9 October 2015

RE: STATE SIGNIFICANT DEVELOPMENT (SSD 6962) AND CONCEPT PLAN MODIFICATION (MP09_0099 MOD4) – RESPONSE TO SUBMISSIONS

This letter details Mirvac's response to these submissions and recommended conditions imposed.

Figure 11: Northern Elevation Proposed Screen Planting – Year 1 to Year 8 Screening Growth

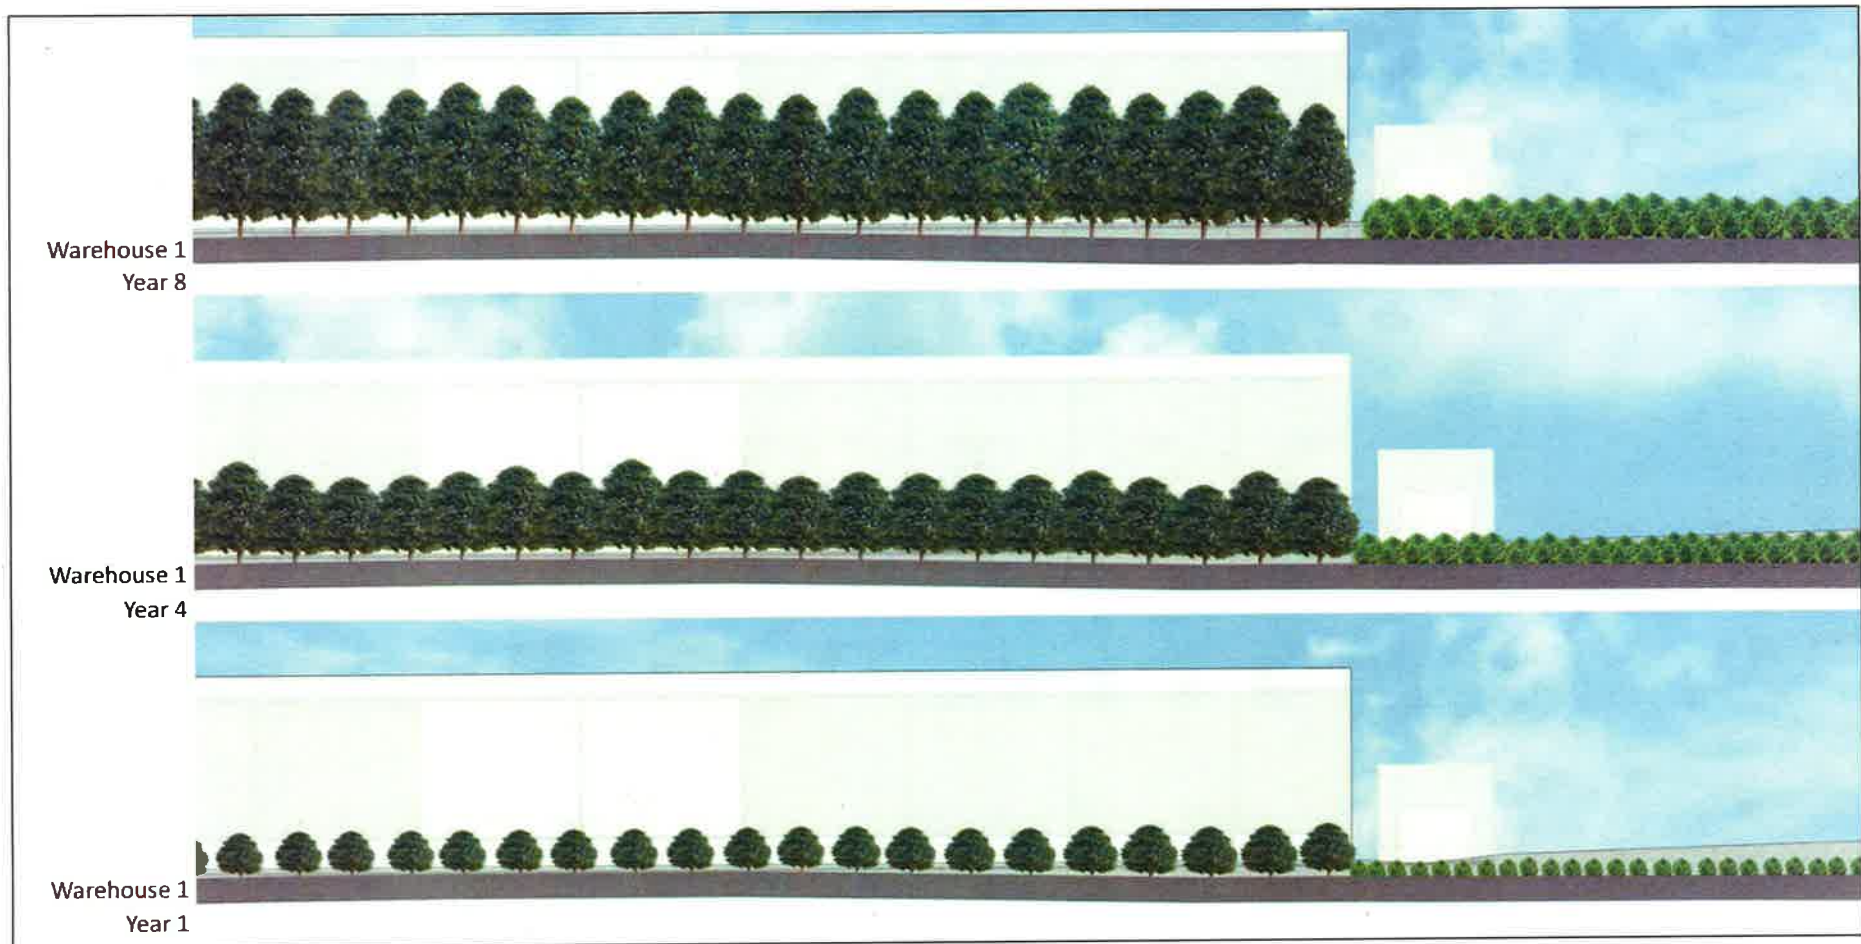
2.3. Council questioned the effectiveness of the tree planting along the northern boundary and requested that adequate screening be provided to eliminate any visual impact from the residential areas to the north and that the landscape area will be able to be appropriately maintained at all times.

Mirvac has committed to minimising the visual impact on nearby receivers by procuring mature 150 Litre *elaecarpus eumundii* trees for planting at the base of the proposed retaining walls prior to completion of construction. This strategy differs from many other developments in which smaller less mature plants are provided initially, which take years to provide any significant screening. The selected tree species is the most appropriate given their ability to grow naturally up to 10m without requiring significant maintenance. Mirvac has progressed this landscaping strategy and the selection of trees in consultation with Invocare (the owners of Pinegrove Memorial Cemetery).

Figure 19: Proposed Stormwater System

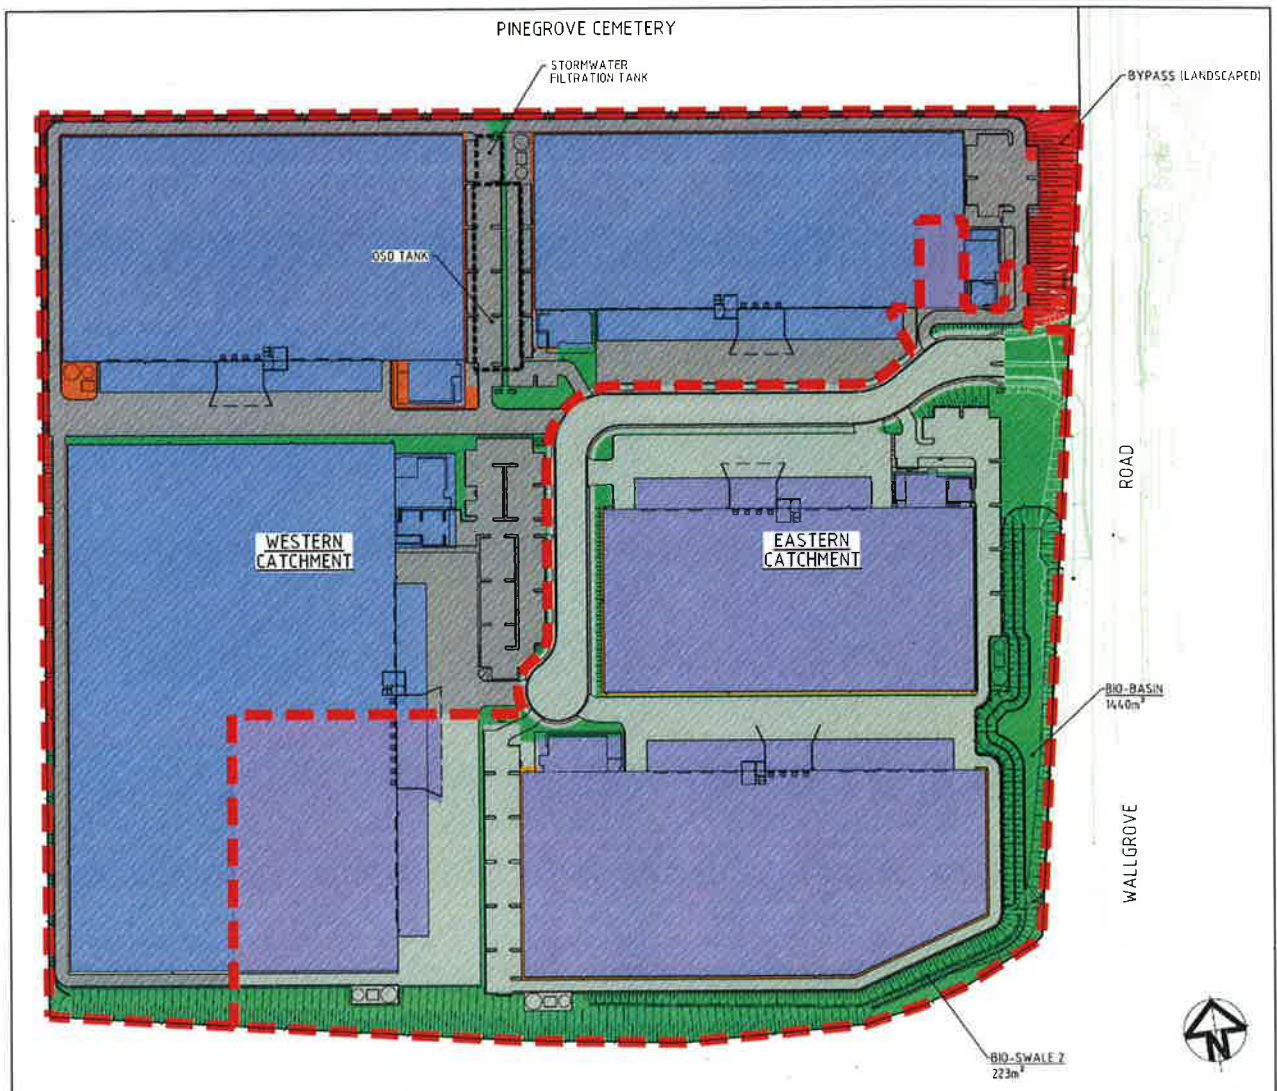
- 8.1. Council's review of the drainage plans suggested that the drainage plans do not match the MUSIC model and that the waterway stability controls in BCC's DCP 2006 have not been addressed.**

AT&L provided a revised MUSIC model to Council for review. Mirvac subsequently provided clarifications with respect to stormwater and drainage design, in a letter to Council contained in **Attachment A**.

It was agreed with Council that amended drawings (where noted) will be provided prior to CC.
